MAJOR PROJECT ASSESSMENT:
Residential Development Buildings 1, 2 & 3
61 Mobbs Lane, Epping – Former Channel 7 Site
MP 10_0107

Director-General's
Environmental Assessment Report
Section 75I of the
Environmental Planning and Assessment Act 1979

December 2010

8 BLDG 2 (TYPE 3) FRONT ELEVATION
1 : 100

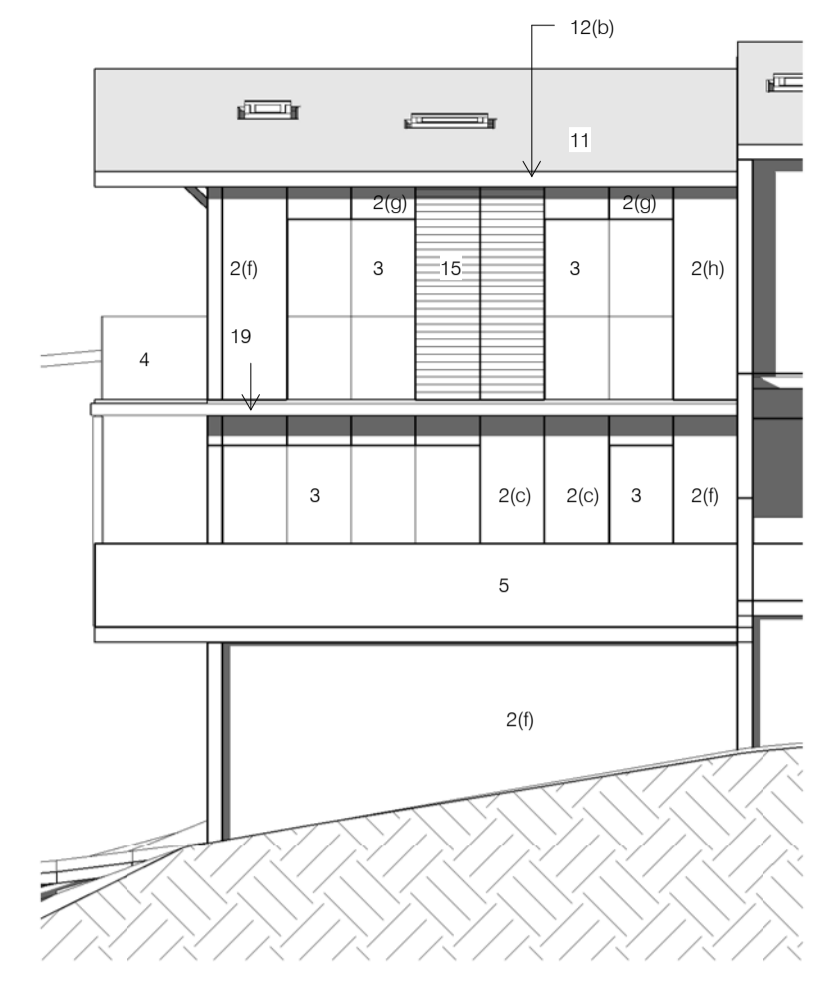
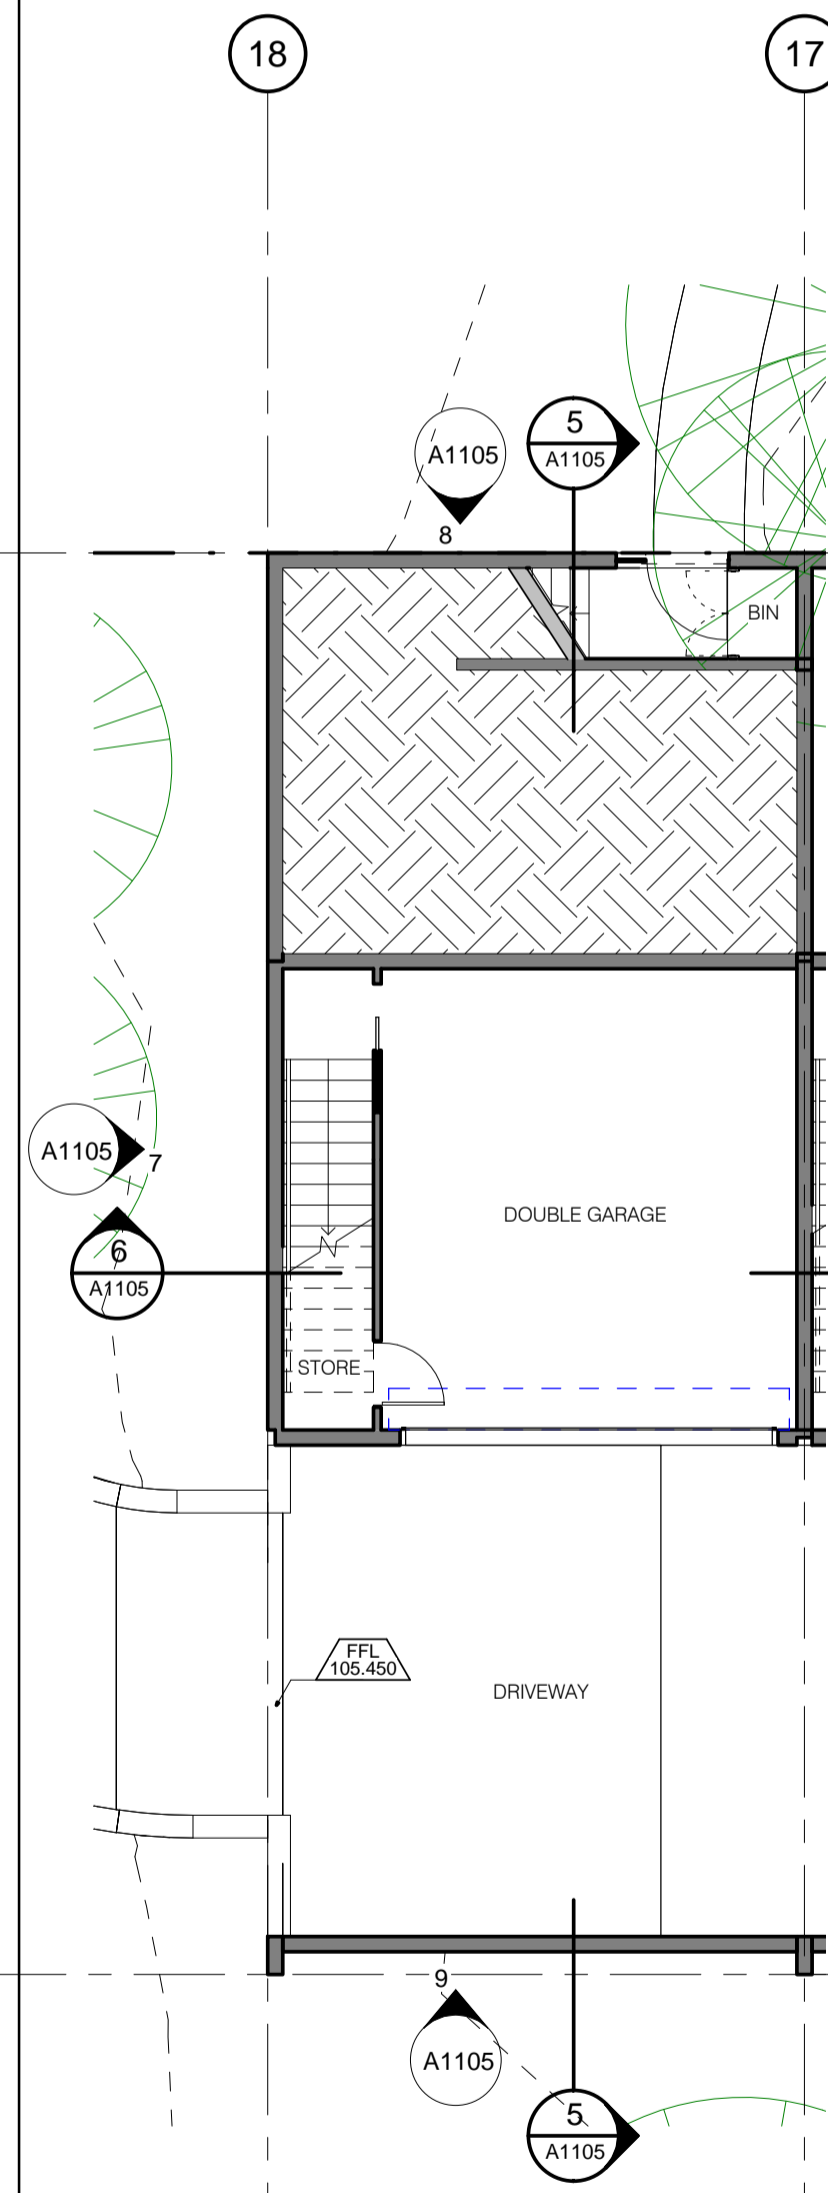
- Buildings 1 and 2 do not provide adequate private open space.
- Front fencing to Buildings 1 and 2 should be reduced to 1.2m with no more than 900mm from ground level being solid.

Council raised concerns regarding the Mobbs Lane street frontage in terms of street activation and opportunities for passive surveillance. Buildings 1 and 2 will provide a positive primary frontage to the internal road network, contributing to the new streetscape character of the former Channel 7 site. The front elevations have been designed to provide a sense of address and visual interest. In accordance with the PDGP 2005, a condition has been recommended in **Appendix E** requiring the front fences to dwellings within Buildings 1, 2 and 3 to have maximum heights of 1.2m above ground level.

7 BLDG 1 (TYPE 1) FRONT ELEVATION
1 : 100

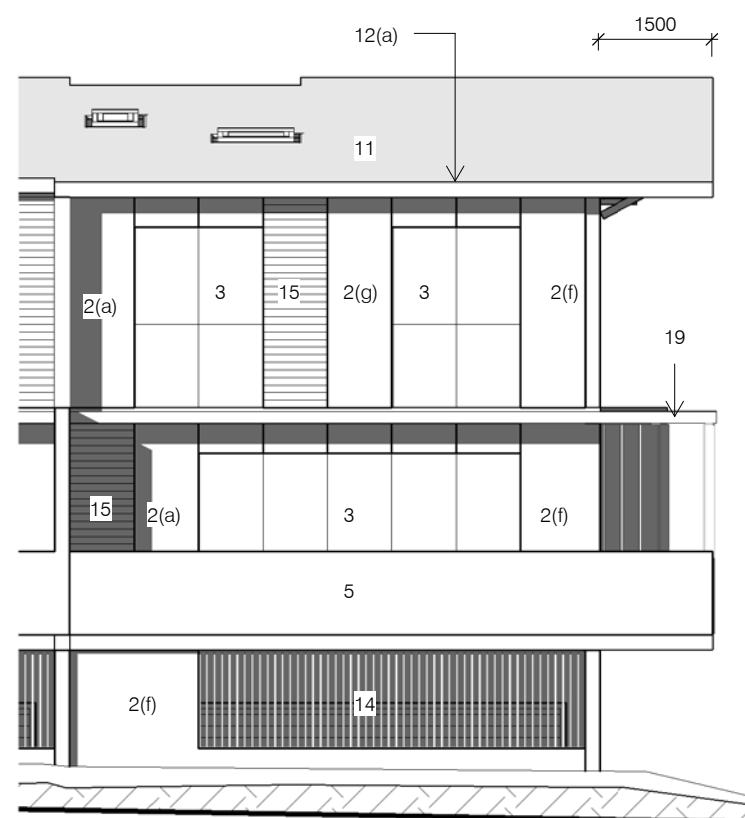
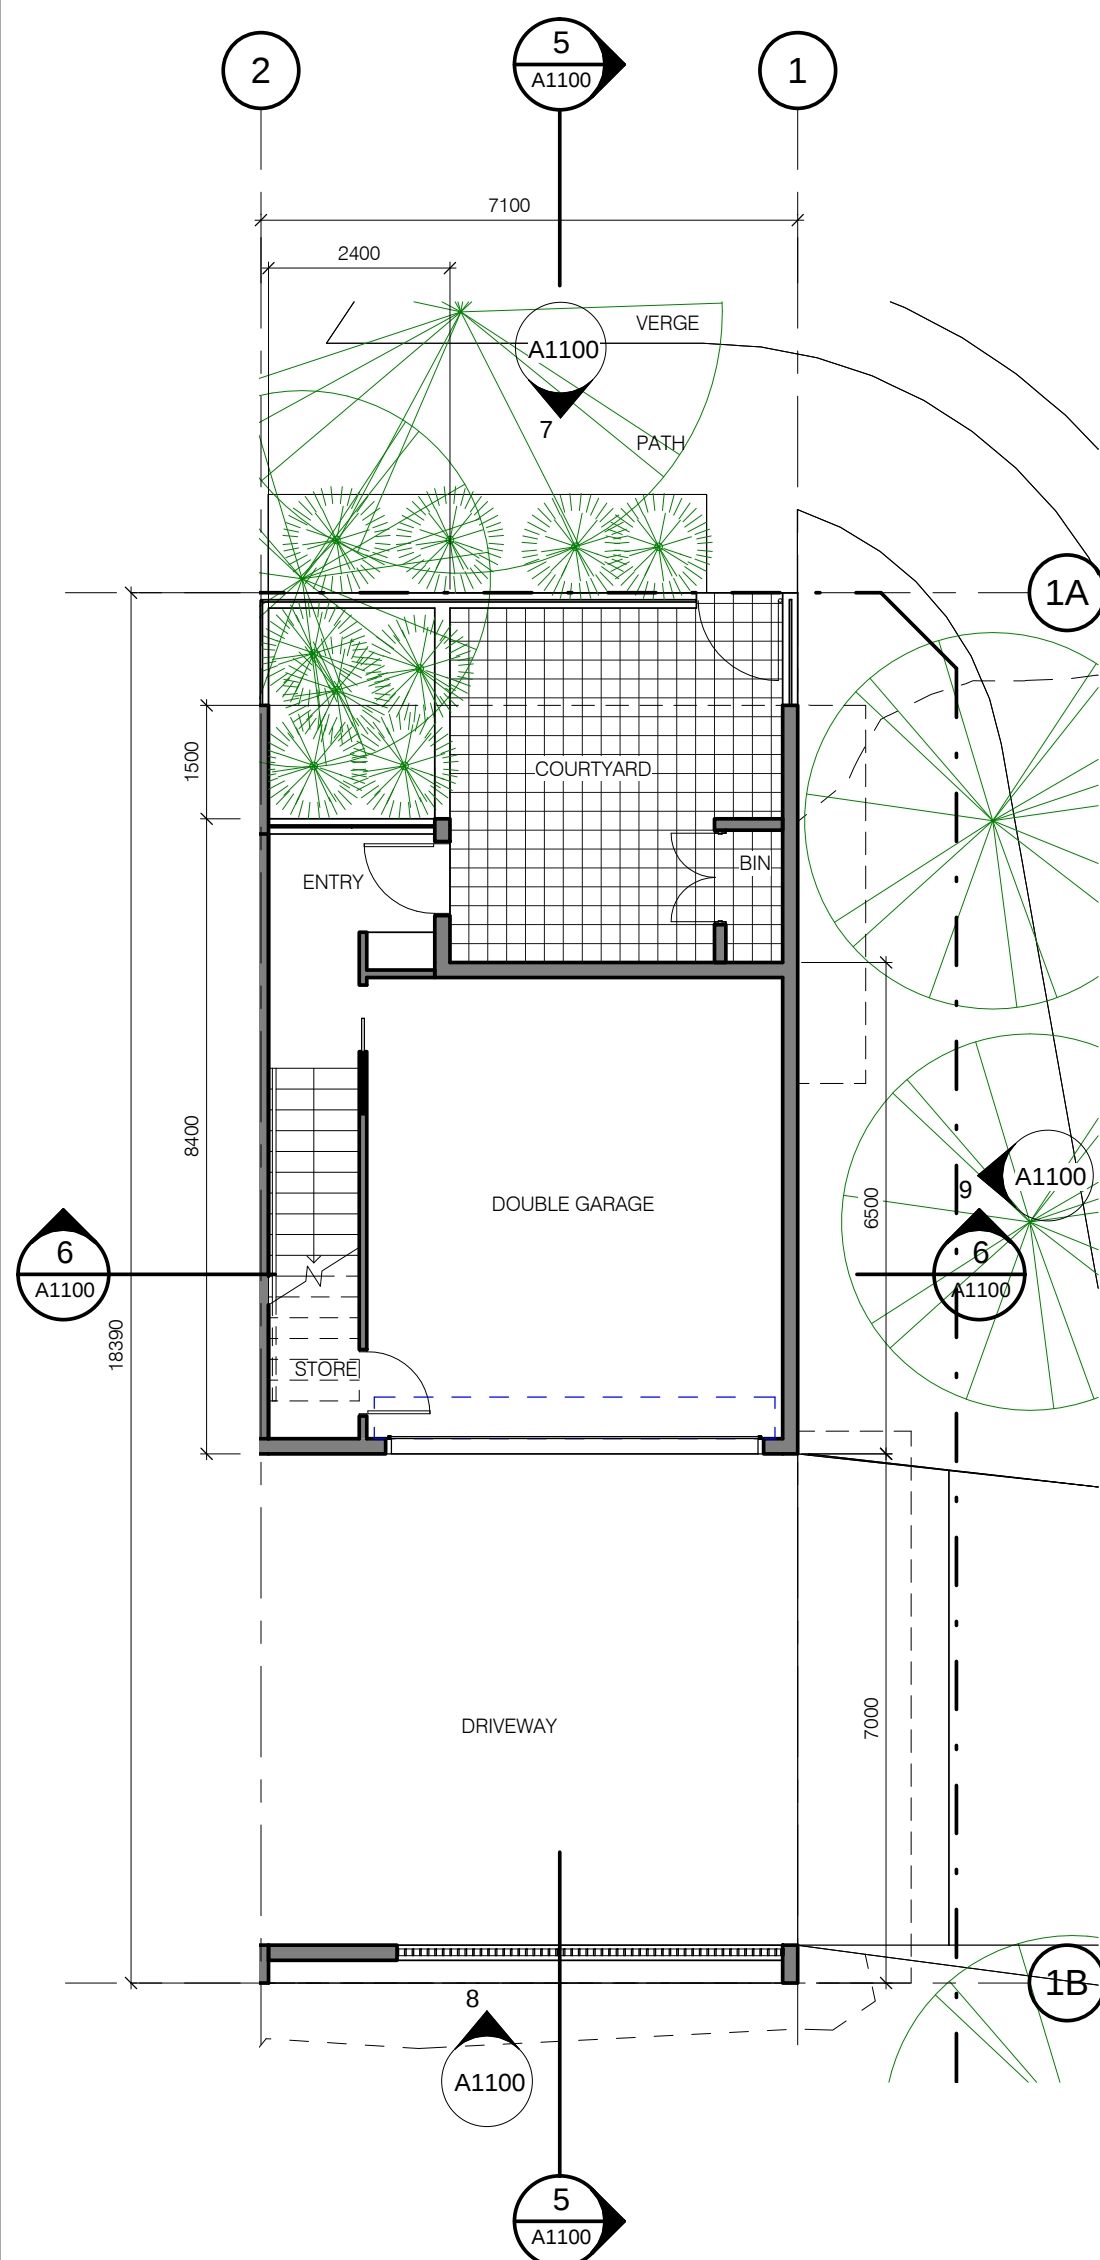
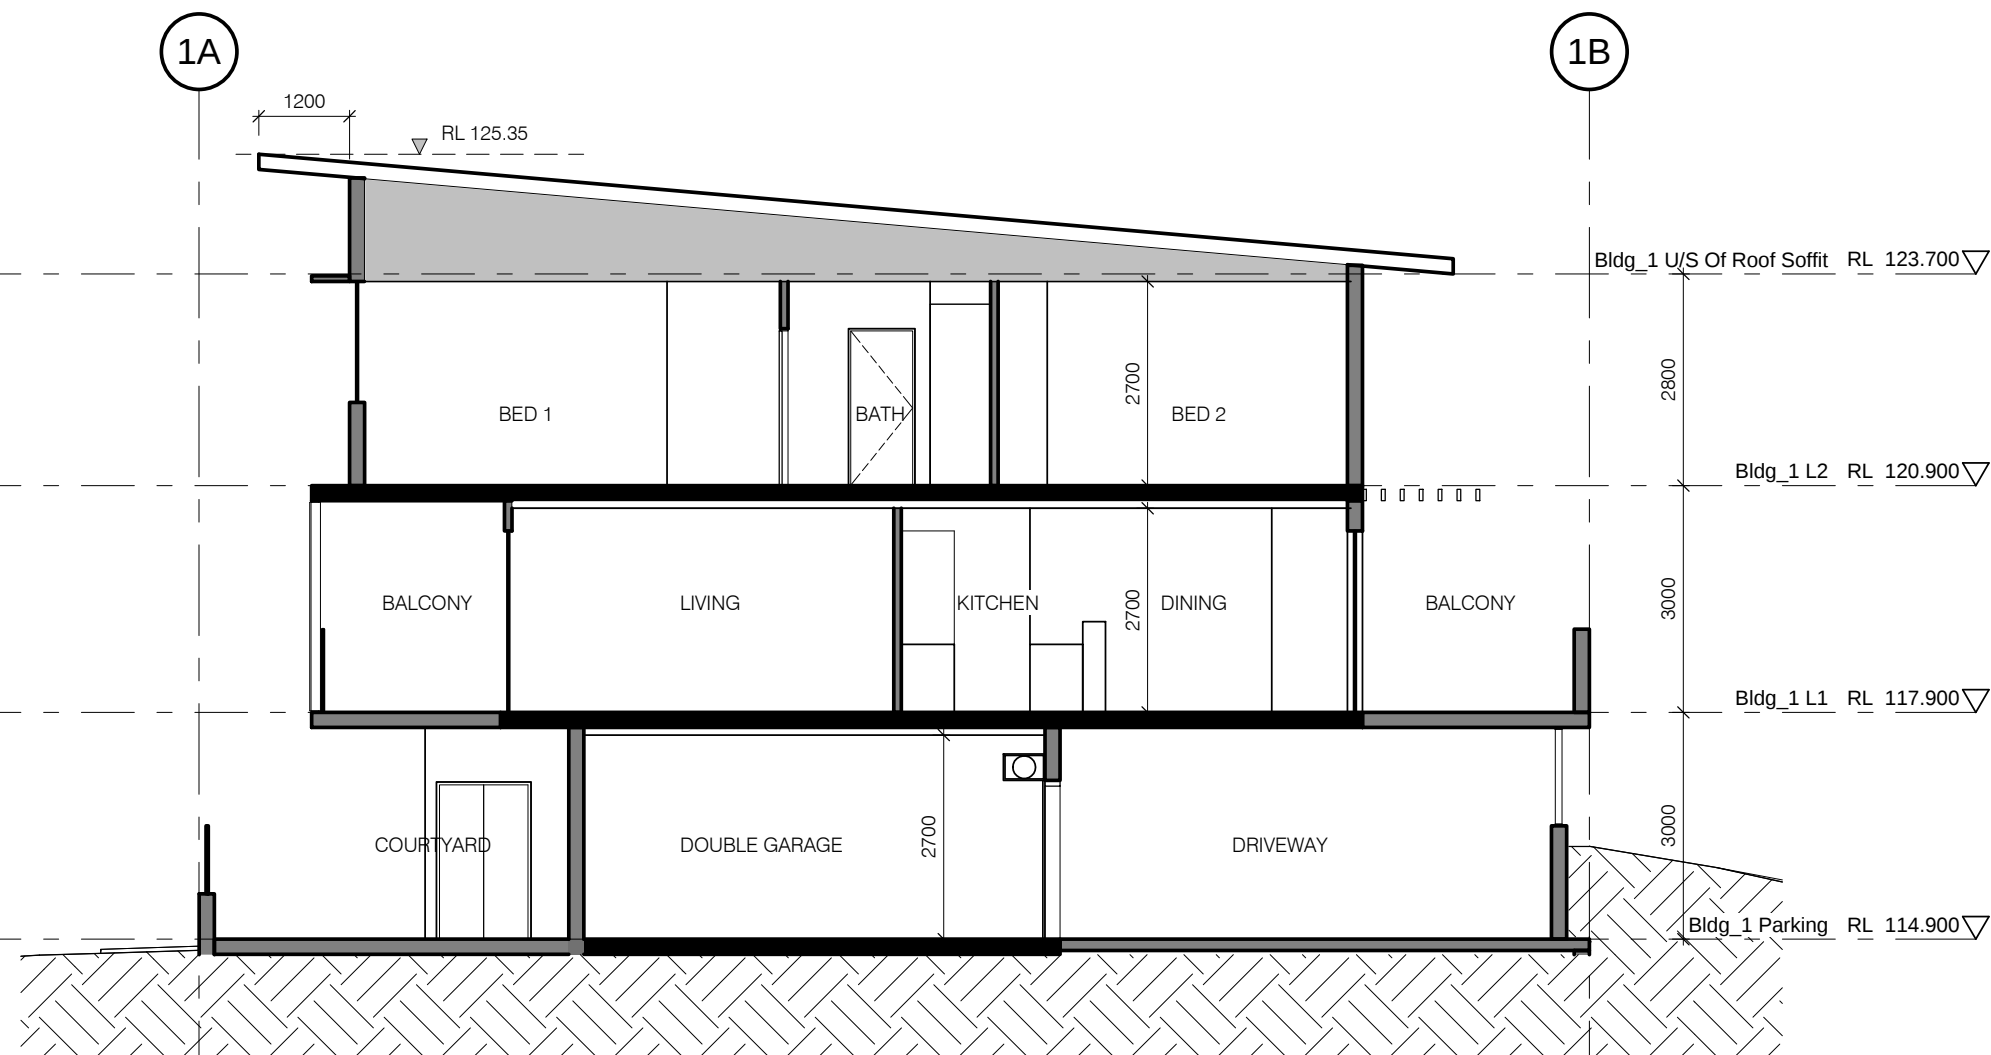
Public Domain Interface of Buildings 1 and 2

The rear building setback and provision of open space at upper levels, to the secondary Mobbs Lane frontage, provides privacy and security for residents, while ensuring a positive relationship with the Mobbs Lane street frontage.
